Phone: 0300 123 6780
Email: Kathryn.Walsh@lancashire.gov.uk
Your ref: 3/2024/1022
Our ref: 3/2024/1022/HDC/KW
Date: 03 February 2025

Location: Highcroft Painter Wood Whalley Old Road Billington BB7 9JD
Proposal: Proposed partial demolition and partial new build of existing five-bedroom dwelling to create a new-build five-bedroom dwelling on the same site.
Grid Ref: 372820 435615

Summary

No objection subject to conditions

project
Highcroft, Billington
job no.
7676
title
proposed ground floor plan
scale
1:100 @ A3
drawing no.
al(05)0100

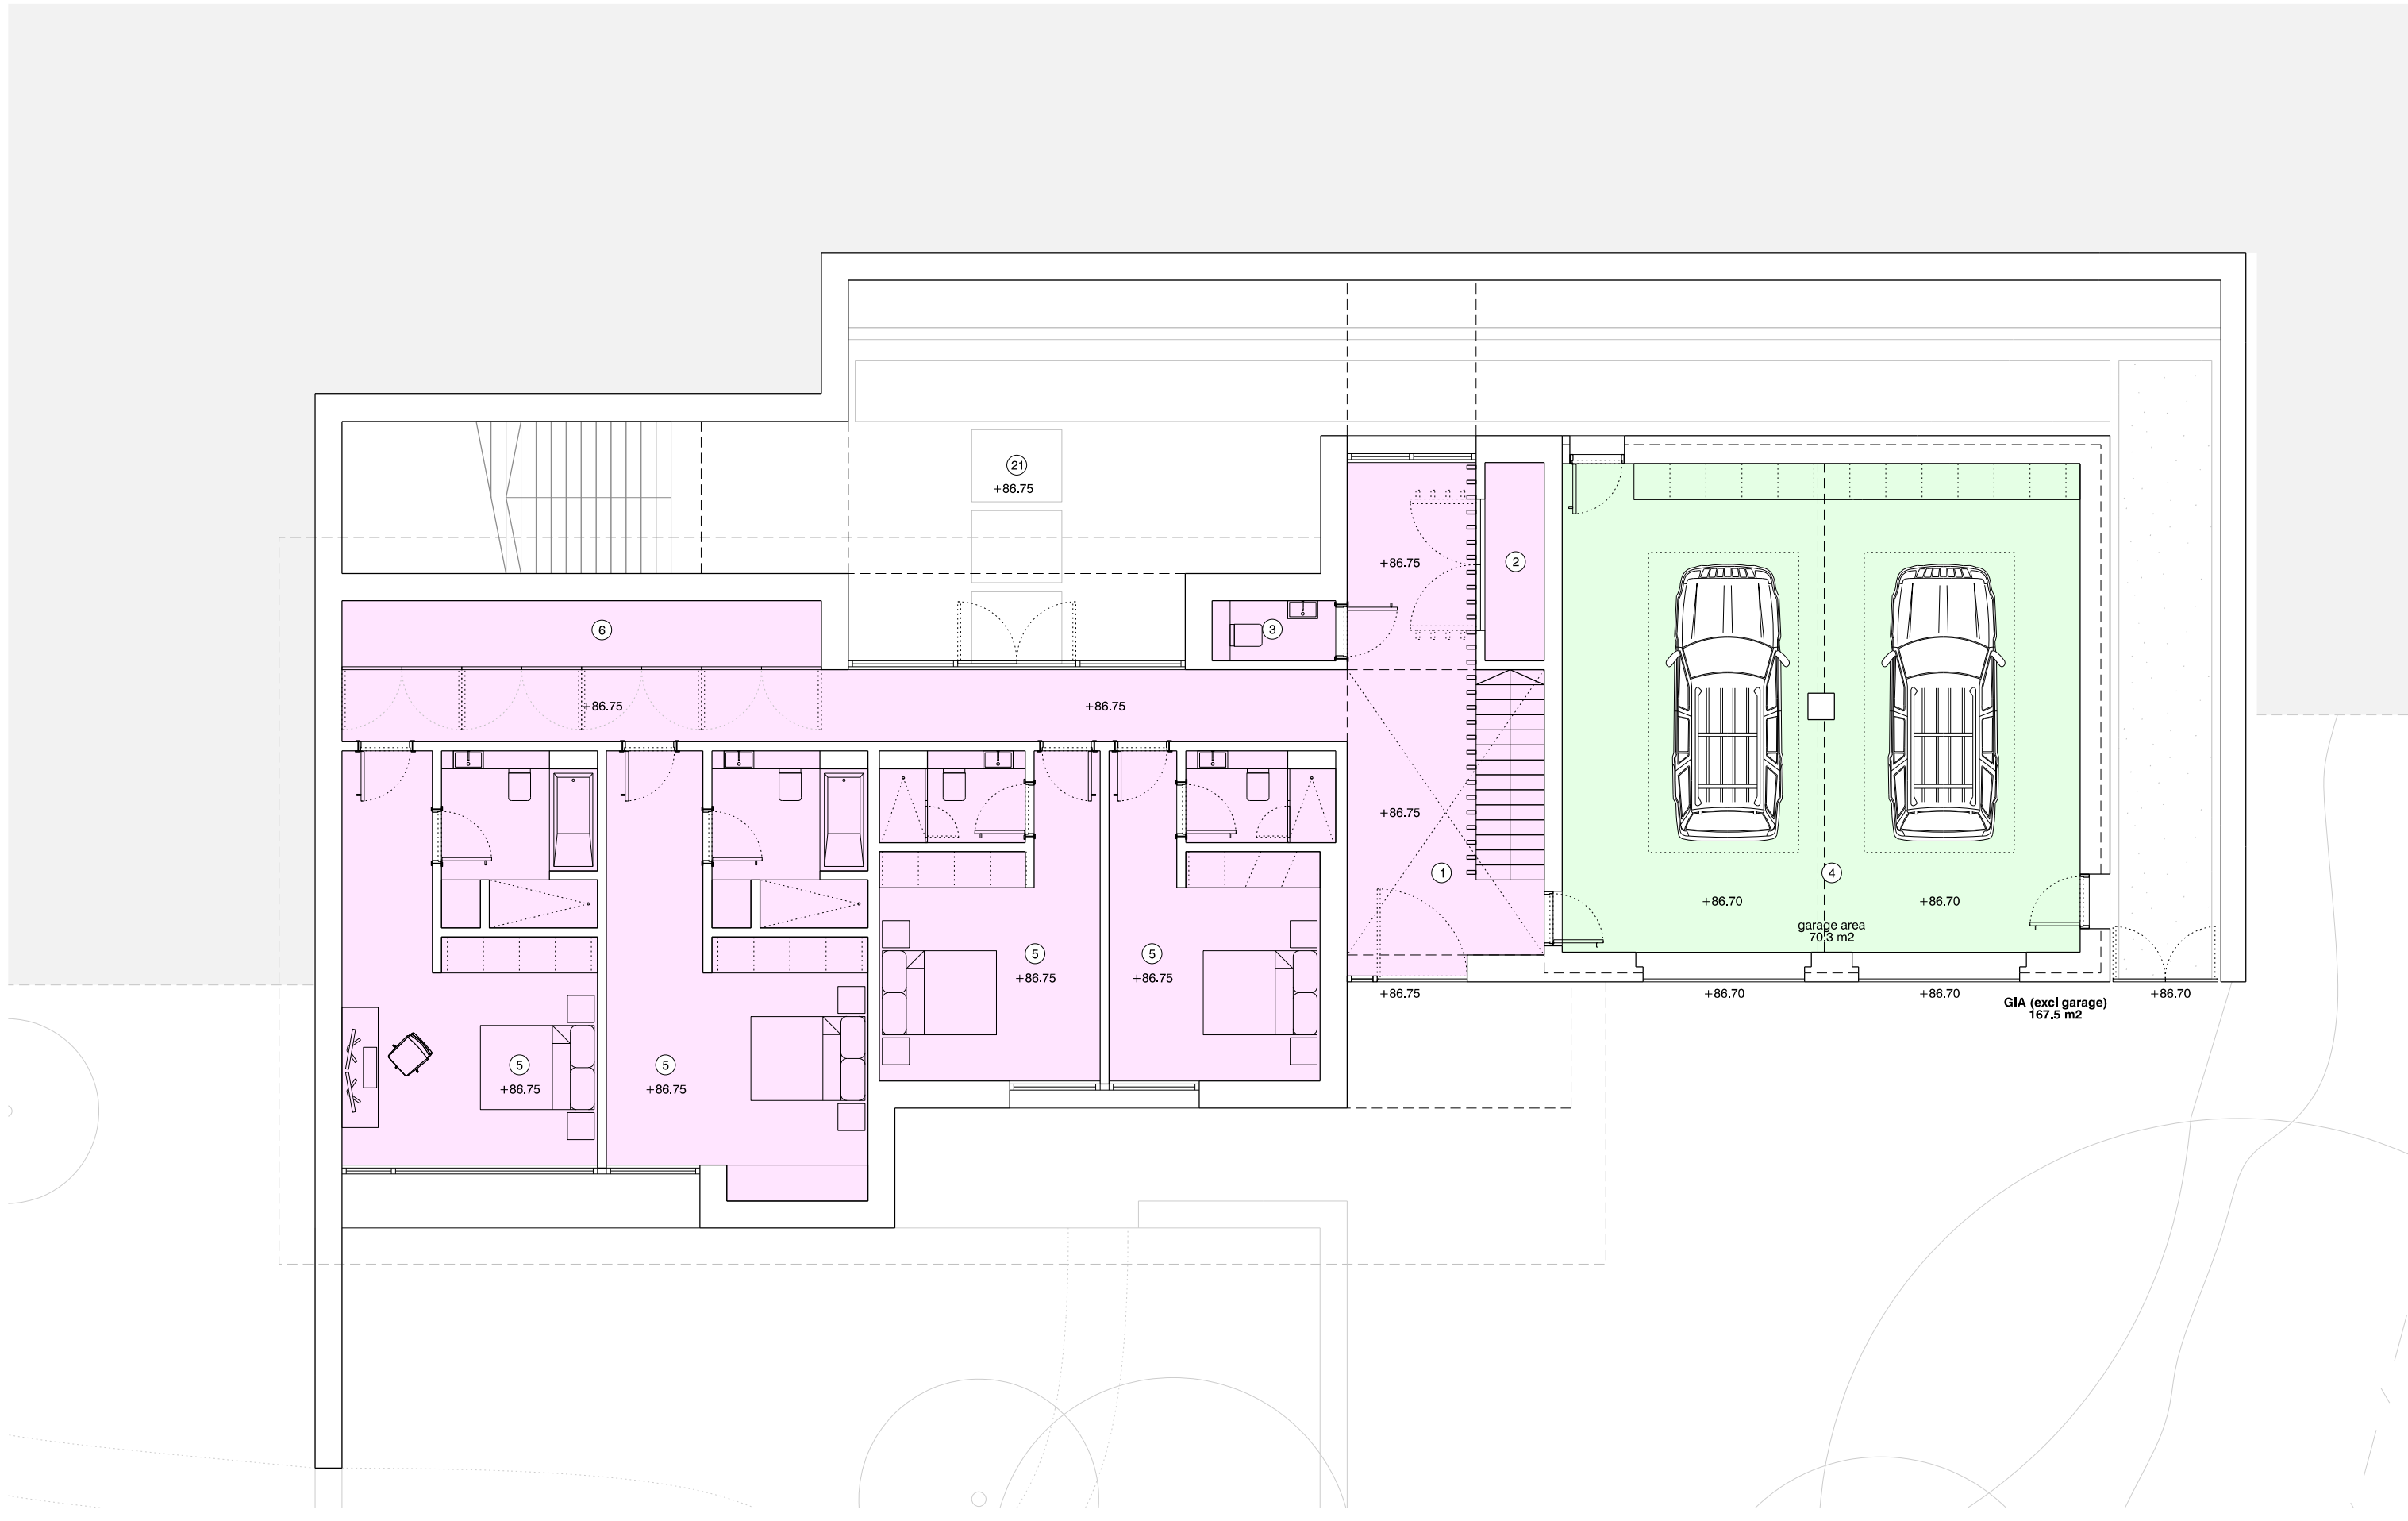
The LHA also reviewed drawing al(05)0100 titled Proposed Ground Floor Plan and noted that the proposed garage meets the LHA recommended minimum internal dimensions for a double garage size which at least 6m in length and 6m wide.

2. The garage hereby approved shall be kept available for the parking of vehicles ancillary to the enjoyment of the household(s) and shall not be used for any use that would preclude the ability of their use for the parking of private motor vehicles, whether or not permitted by the provisions of the Town and Country Planning (General Permitted Development) Order 2015 or any order amending or revoking and re-enacting that order.
Reason: To ensure that adequate parking provision is retained on site.

project
Highcroft, Billington
job no.
7676
title
proposed site plan
scale
1:200 @ A3
drawing no.
al(05)0150

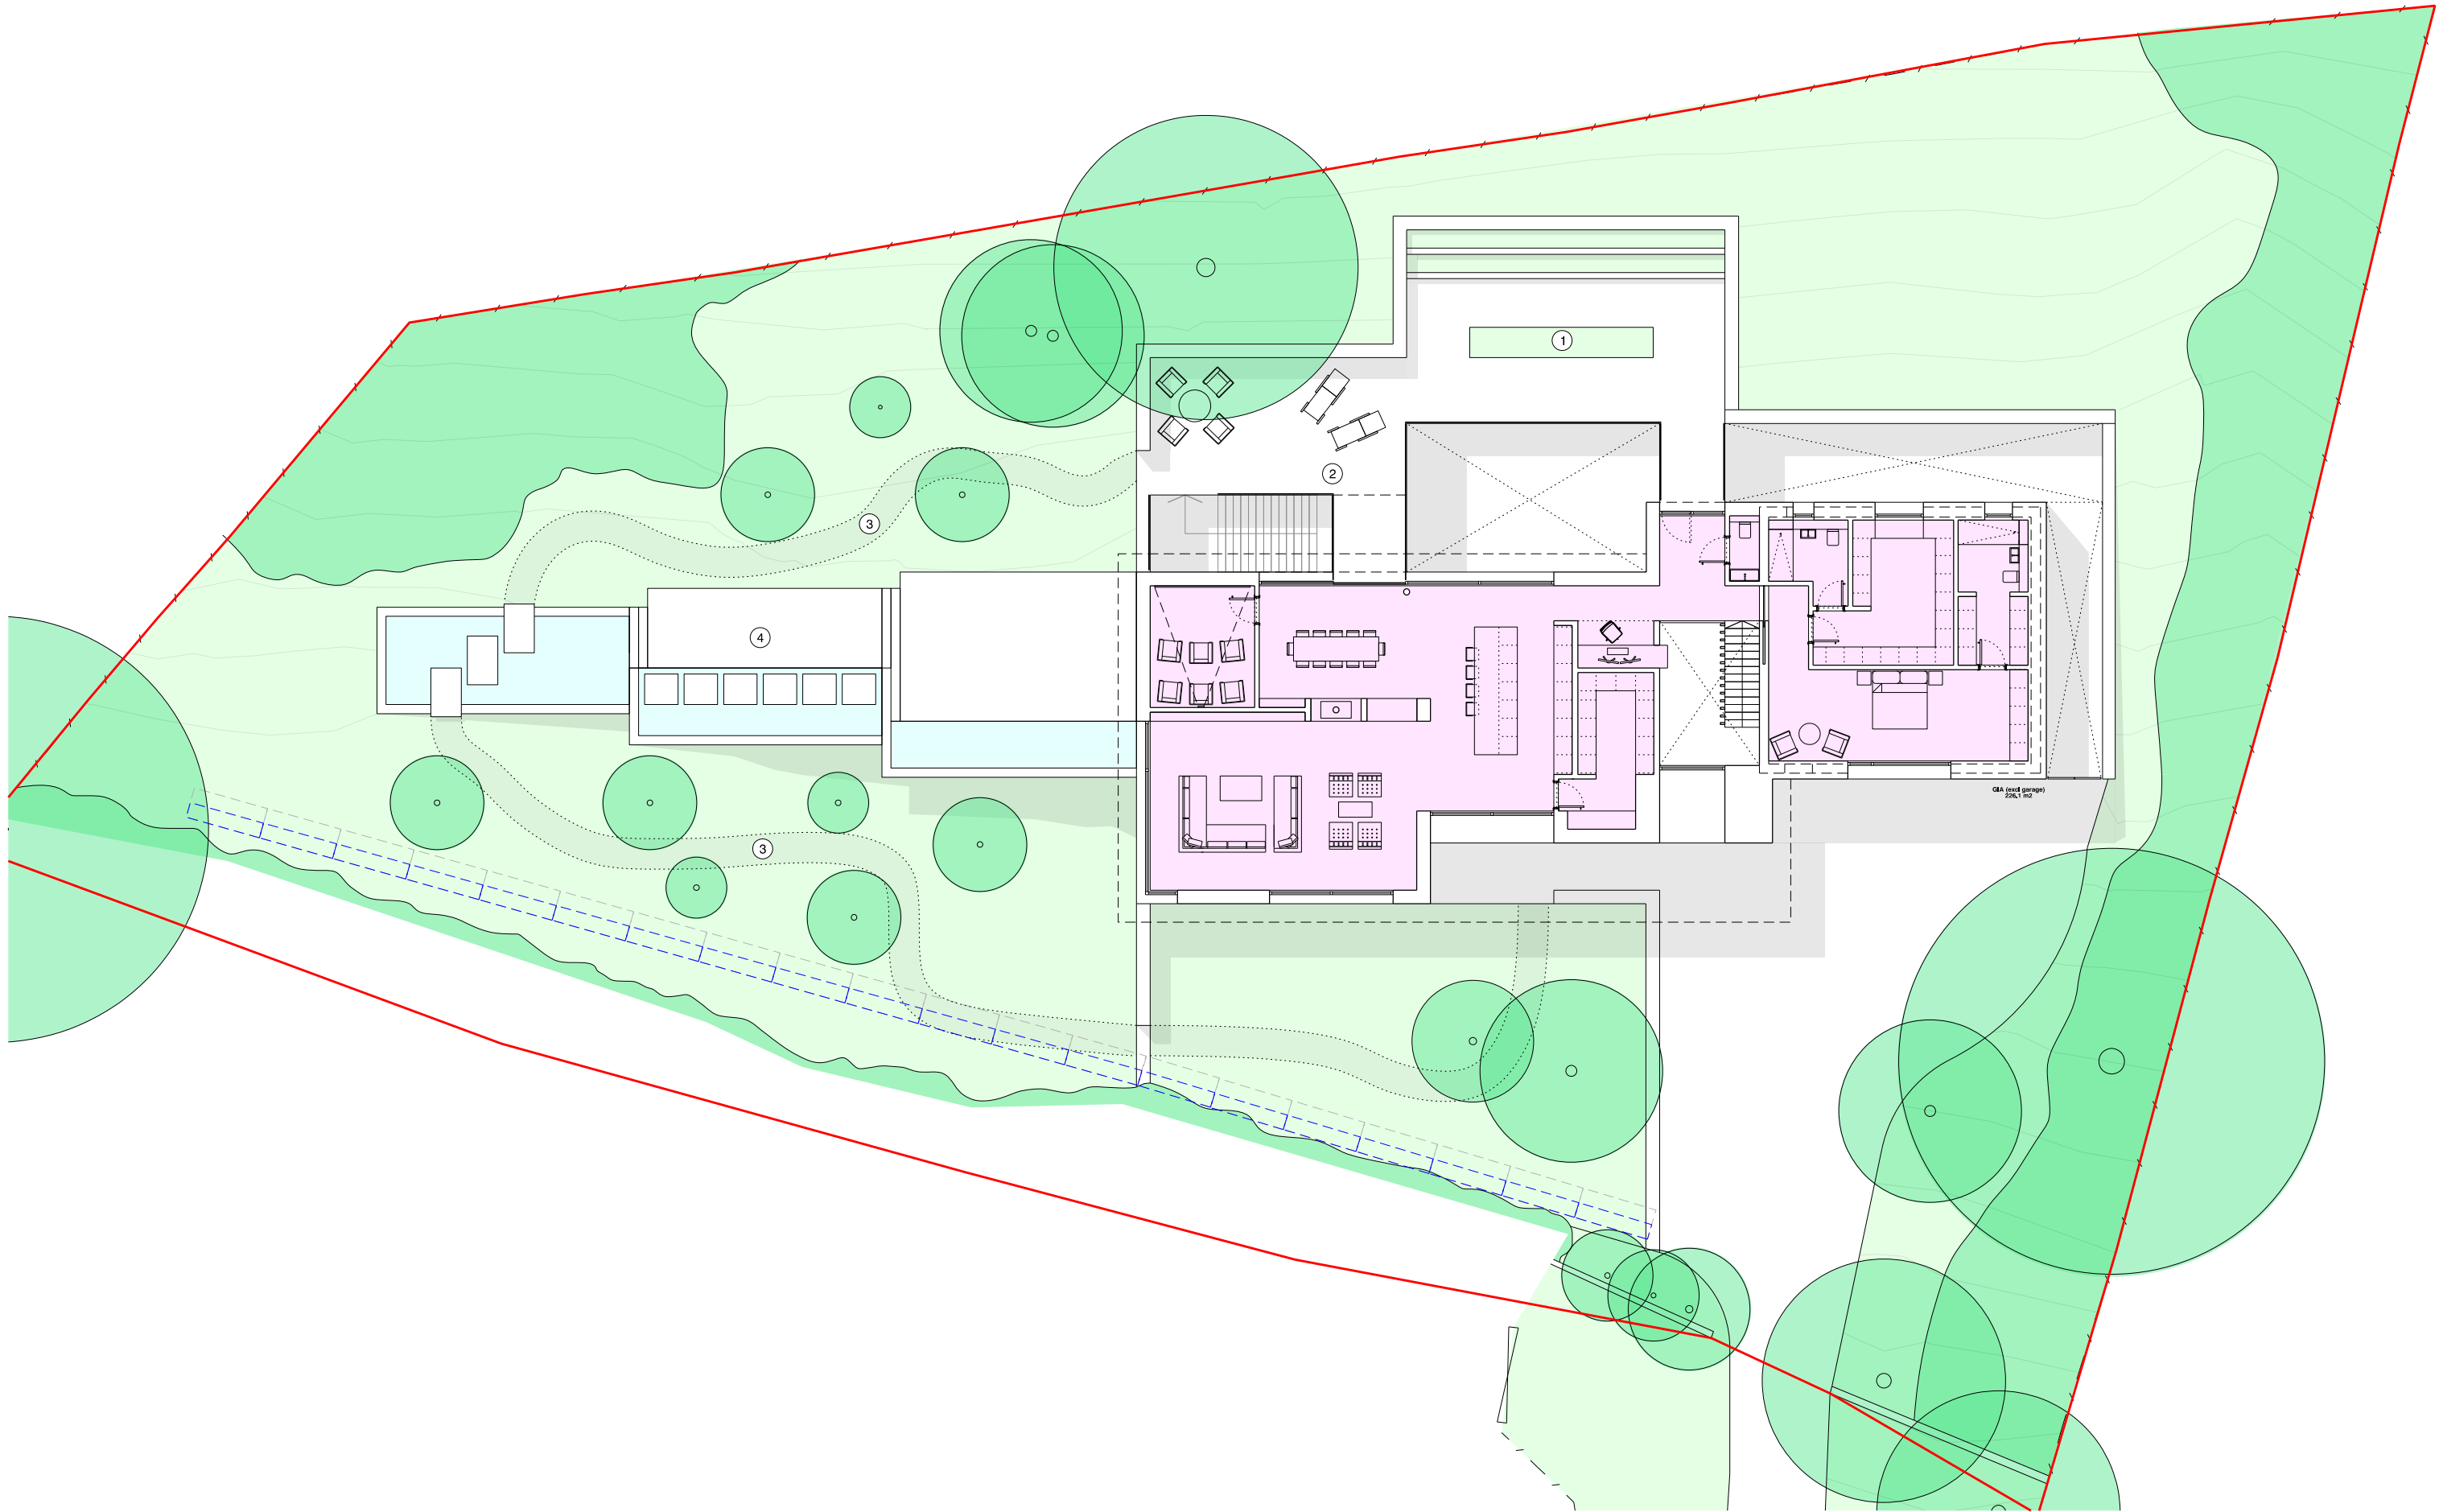
The LHA has reviewed drawing number al(05)0150 titled Proposed Site Plan and are aware that the dwelling complies with the LHAs parking standards as defined in the Joint Lancashire Structure Plan. There is also room to turn within the site and leave in a forward gear.

1. The development hereby permitted shall not be brought into use until the car parking and turning areas shown on the approved plan(s) have been provided in full and are available for use. The car parking and turning areas shall thereafter be kept available for the parking and manoeuvring of vehicles at all times.
Reason: To ensure the provision of adequate car parking on site and in the interests of highway safety.
